From: [REDACTED]
To: [DraxBECCS](#)
Cc: [REDACTED]
Subject: EN010120 Drax BECCS Natural England Deadline 4 response
Date: 28 March 2023 15:14:37
Attachments: [image001.png](#)
[426179 EN010120-Natural England Response - Deadline 4.pdf](#)

NSIP Reference Name / Code: EN010120

Title: Natural England's updated comments in respect of Drax Bioenergy with Carbon Capture and Storage Project, promoted by Drax Power Limited

Examining authority's submission deadline 28 March 2023

Figure 1: River Derwent SAC / Lower Derwent Valley SAC Habitat Monitoring

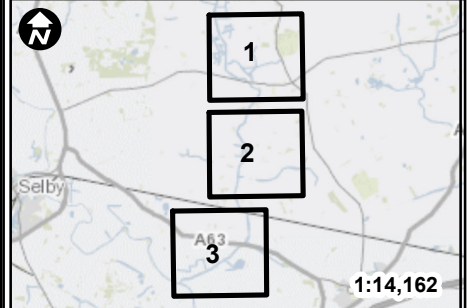
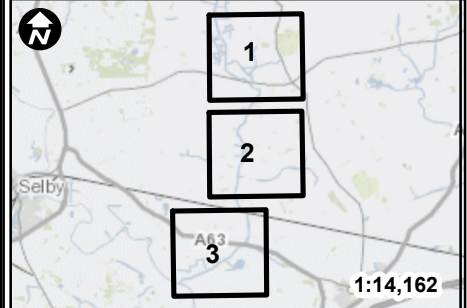
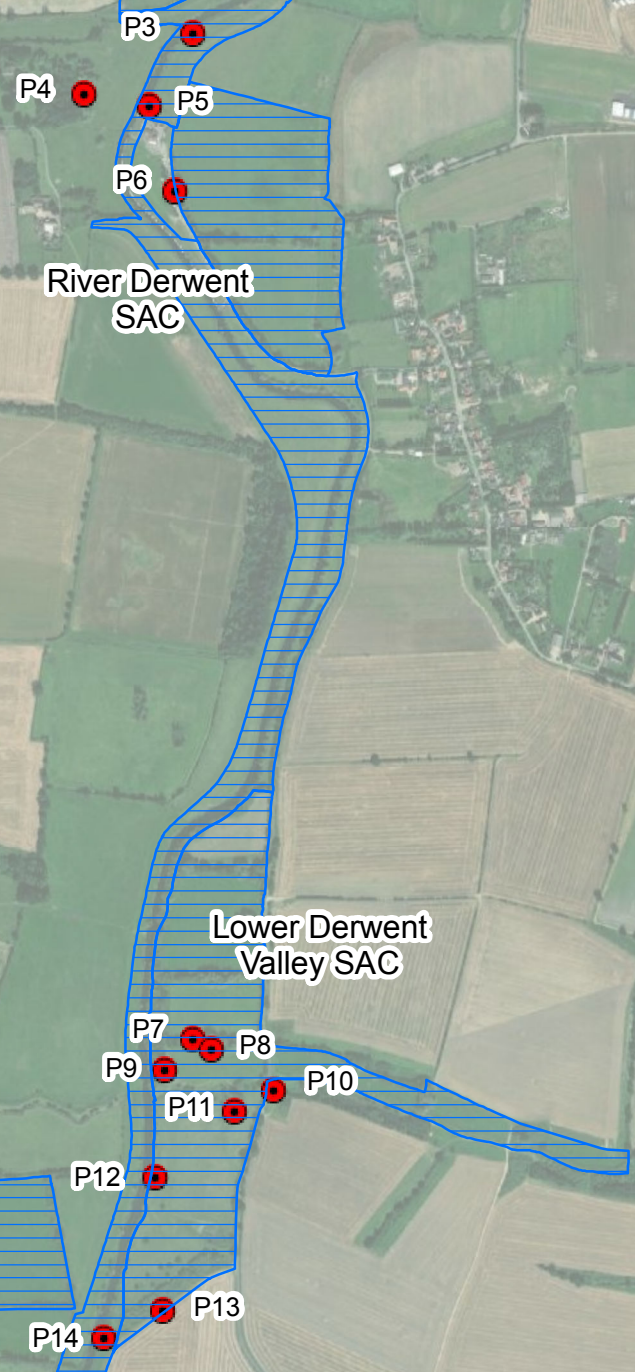
<p>Further information is provided in the HRA in relation to the residual in-combination impact (e.g., section 4.3.54 onwards) and refers to habitat survey work and analysis (Appendix 7 document reference 6.8.3.7) to confirm the habitats present along the River Derwent SAC and Lower Derwent Valley SAC. The survey data (see Table 1 in Appendix 7) found evidence of agricultural improvement within a number of field units within and bordering the Lower Derwent Valley. The evidence of agricultural improvement suggests the surveyed locations are likely to be relatively insensitive to additional aerial nitrogen and acid deposition inputs.</p> <p>The applicant has also provided a habitat analysis report for this site, based on Natural England survey data (Habitats Regulations Assessment Volume 3 – Appendix 8 Lower Derwent Valley Habitats and Soil Analysis Reference 6.8.3.8), which concludes that neutral grassland is the most abundant broad habitat type - although a greater number of the plots sampled were in the ‘calcareous’ rather than ‘acid’ or acid-neutral’ pH ranges. It may therefore be more appropriate to conclude that the acid critical load for calcareous grassland is more relevant than that for acid, which allows for greater pH buffering capacity – making the site potentially less sensitive to acid deposition. This therefore supports the conclusion that the conservation objectives of these sites would not be undermined.</p>	<p>(and other pollution) in the area is decreasing, leading to improvement of the protected sites, and also that the precautionary assumptions within the modelling in the assessment were appropriate, to conclude that the conservation objectives of the protected sites would not be undermined (alone or in combination). Monitoring would provide confirmation of the continued reduction in impacts of atmospheric pollution at the protected sites, and any changes in plant communities resulting from that, rather than considering the proposed scheme specifically.</p> <p>However, it is accepted that this is not a necessary measure to ensure protection of the sites (as it would not be possible to attach to any “triggers” to highlight risk occurring requiring further protective measures to be employed) so will not require such a measure to be included in the DCO.</p>

¹ It is noted that the in-combination figures provided in the Appendix 7 report are different to those in the HRA. It is understood this was due to a drafting error in rounding of figures – the cumulative percentage of critical load in Table 3 of Appendix 7 has been incorrectly rounded down to 0.6% instead of rounded up to 0.7%. The Applicant has agreed to update this in response to these Deadline 4 comments. This is not a point of disagreement as long as these changes are made.

<p>deposition critical load for the riparian vegetation, evidence is provided in Appendix 6 of the HRA (reference 6.8.3.6) that the SAC is skewed towards phosphate limitation, again indicating that there will be limited impact on nitrogen deposition on the qualifying features. Although Natural England advised that a precautionary approach is taken to applying this information in the context of additional inputs of nitrates on the River Derwent SAC/SSSI, the information the Applicant provided in their Response to Relevant Representations (reference 8.3 - line 5.30) that combined with other evidence (including the revised HRA and SAC monitoring report) the extent of phosphate limitation, and the measures proposed to mitigate for adverse effects that could potentially occur from nitrogen deposition from aerial emissions as a result of the proposal, Natural England advises that we concur with the assessment conclusions that there will be no adverse effect on site integrity, providing that all mitigation measures are appropriately secured.</p> <p>The requested change to Table 3 in the SAC Habitat Monitoring report (reference 6.8.3.7 - HRA Appendix 7 – SAC Habitat Monitoring) as noted in footnote 1 is required.</p>
